Gatwick Airport Northern Runway Project

Statement of Common Ground Between Gatwick Airport Limited and Environment Agency

DATE: MARCH 2024

Application Document Ref: 10.1.12

Figure 4.1: Schematic of Museum Field FCA

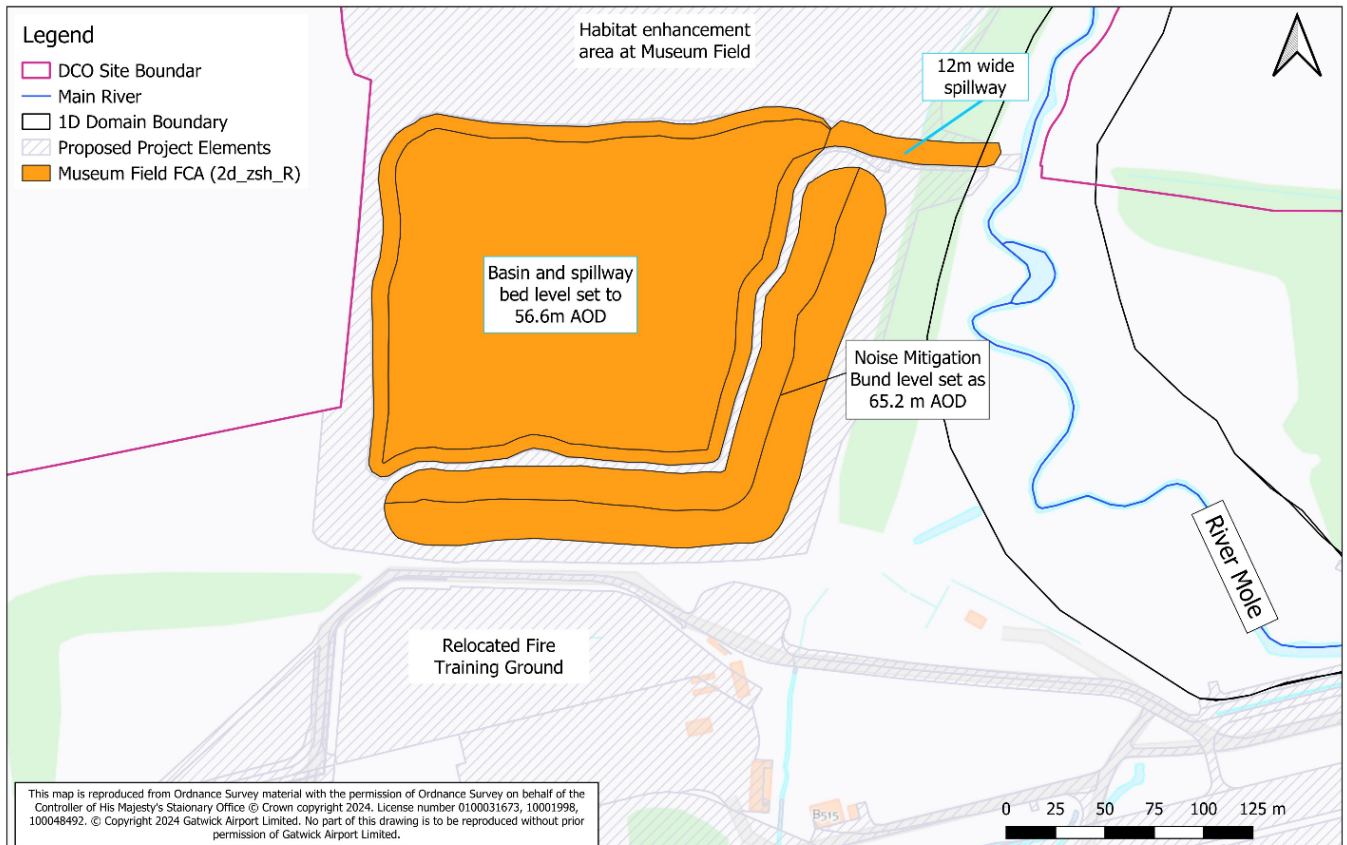
2.8.3.1	Museum field: retaining existing mature habitat where it is compatible with the function of flood compensation area	There are existing mature trees situated within in the Museum Field, which were discussed in a previous joint consultation meeting whether these might be retained and could be assessed for compatibility with the function of that flood compensation feature. The landscaping plans refers to a clear space with new grassland being created within the flood compensation area and note the landscaping design approach which will test the suitability of existing habitat features for incorporation and retention. However, it remains unclear about the fate of these trees within the Museum field flood compensation area, and therefore request clarification. The approach is welcome with established river corridor habitat structures and commitments to protect these sensitive receptors from light pollution at all phases of development.	The flood compensation area has been sized and designed to ensure that the majority of trees that surround the area are retained. The only exception will be a small section on the eastern boundary to facilitate connection to the River Mole. An Arboriculture Impact Assessment and Tree Protection Plan are being produced and will be shared once available.		Agreed
